Consultation Response from: KC Environmental Health (Pollution & Noise Control)		
2021/92427 - 48, Stile Common Road, Primrose Hill, Huddersfield, HD4 6DE		
Discharge conditions 9 and 10 on previous permission 2020/91228 for demolition of existing dwelling and erection of residential development to form student accommodation with associated access and parking		
Date Responded: 22nd December 2021	Responding Officer: Natalie Heaney	Responding Ref: WK/202125277
Conditions 9 and 10 were recommended by the Coal Authority and relate to the Coal Mining legacy. Environmental Health were not originally consulted on previous permission 2020/91228. We acknowledge there is an overlap with Condition 9 as the coal mining legacy features may present an environmental health risk (e.g. from mine gases or combustion). Condition 10 relates to surface stability. This is outside the remit of Environmental Health. Condition 9 – Intrusive Site Investigation Works (Coal Mining Legacy) To date Environmental Health has commented the following documents: • A Coal Investigation report by Rogers Geotechnical Services Ltd, dated 10th June 2021 (ref: C337/20/E/1956). • An Addendum titled 'Gas Monitoring at Stile

Section A-A

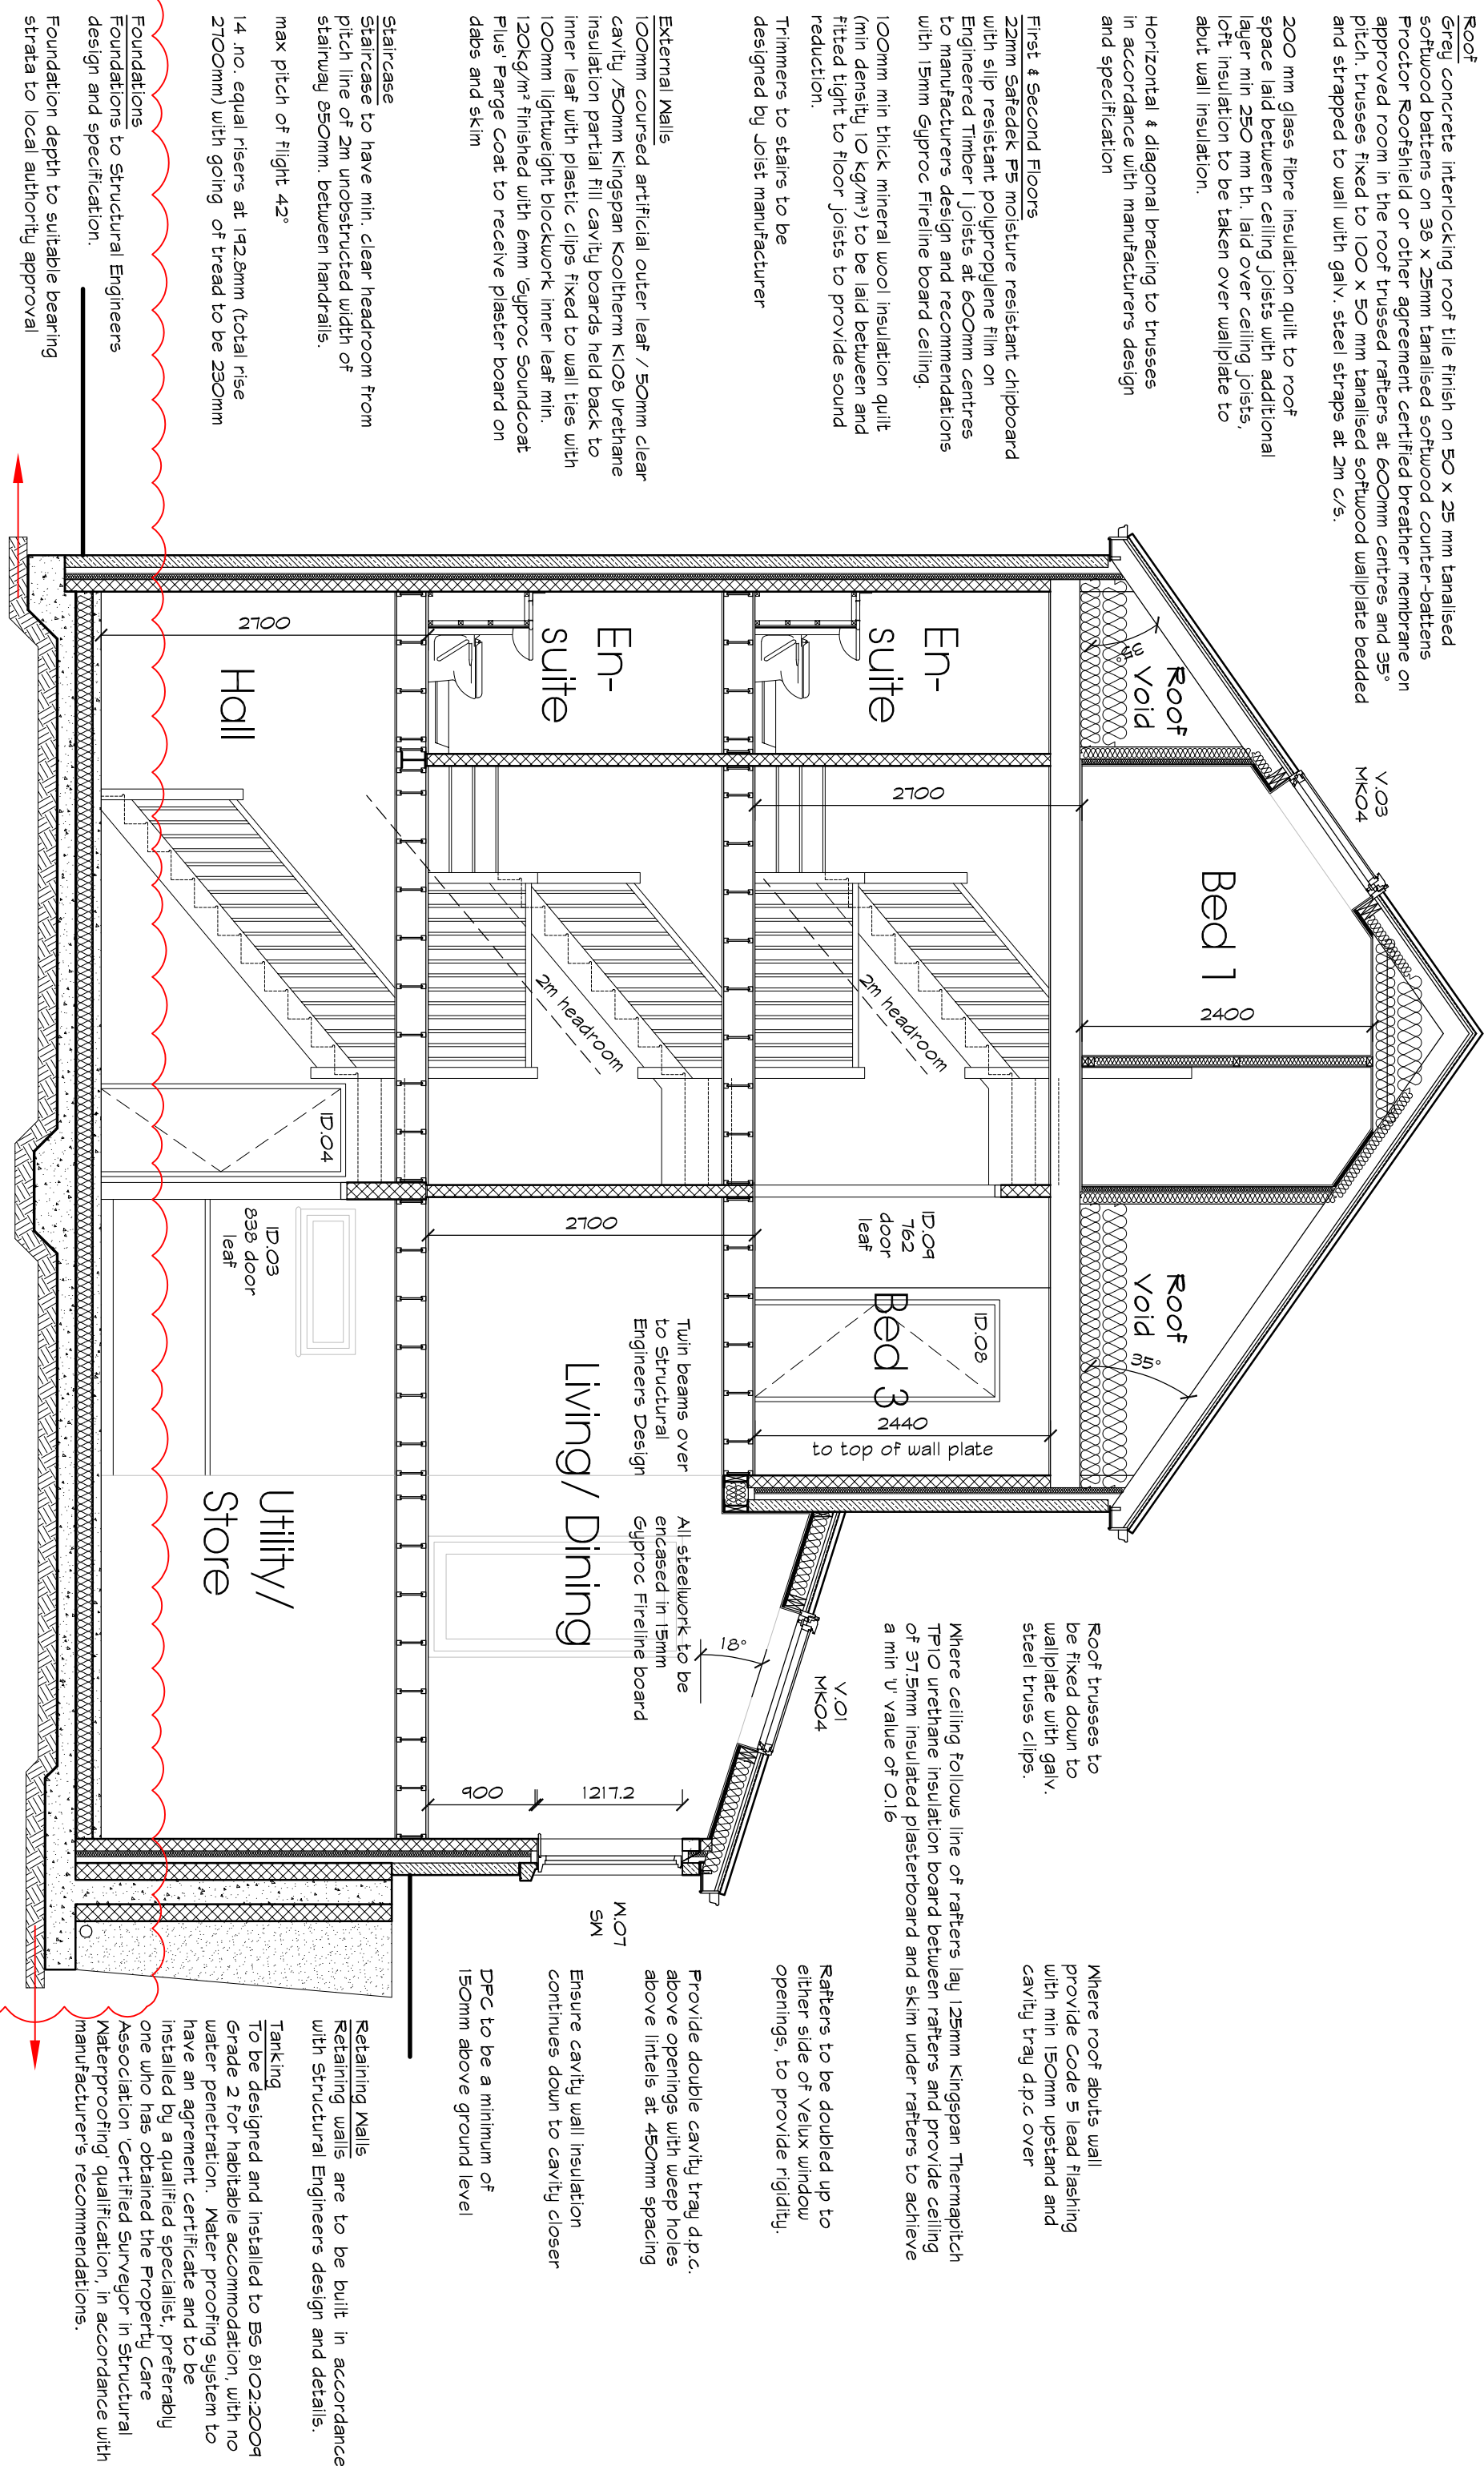
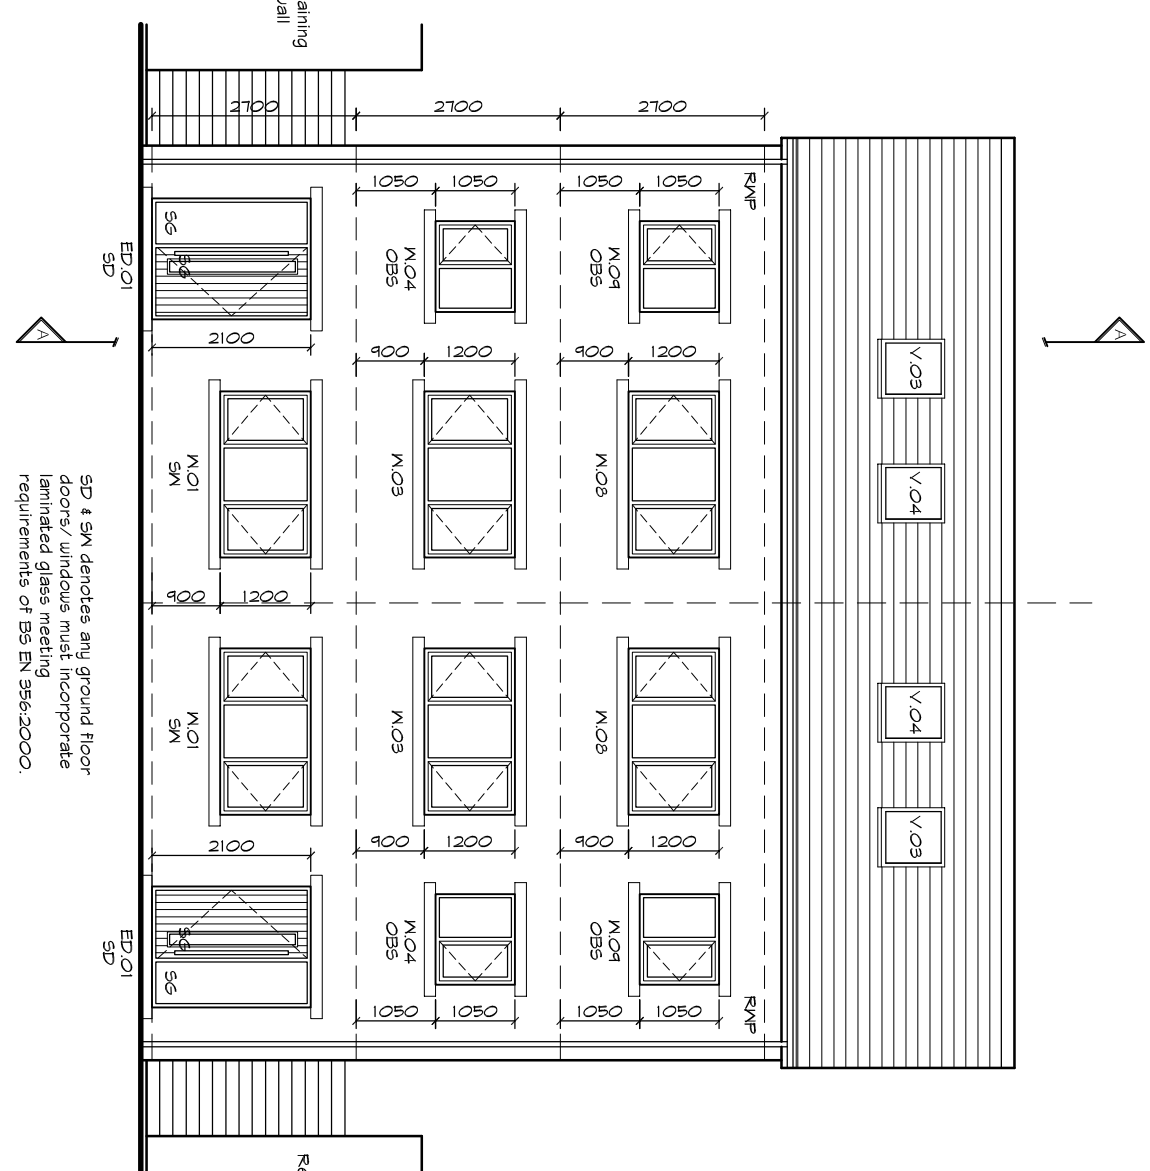
We have read the report provided and whilst we recognise that remedial measures are proposed to treat the shallow mine workings, we do not accept the proposals for CS2 gas protection measures. We consider the data set to remain limited as the readings were taken from one borehole only and at barometric pressures >1000mBs. As such we do not have confidence in the dataset.

Moving forward, we would accept the installation of Characteristic Situation Level 3 (CS3) gas protection measures at the site to secure safe occupation of the site. The combination of protection elements to be installed must also be confirmed and proposals for validation put forward. Until we receive revised proposals, we cannot recommend the discharge of Condition 9.
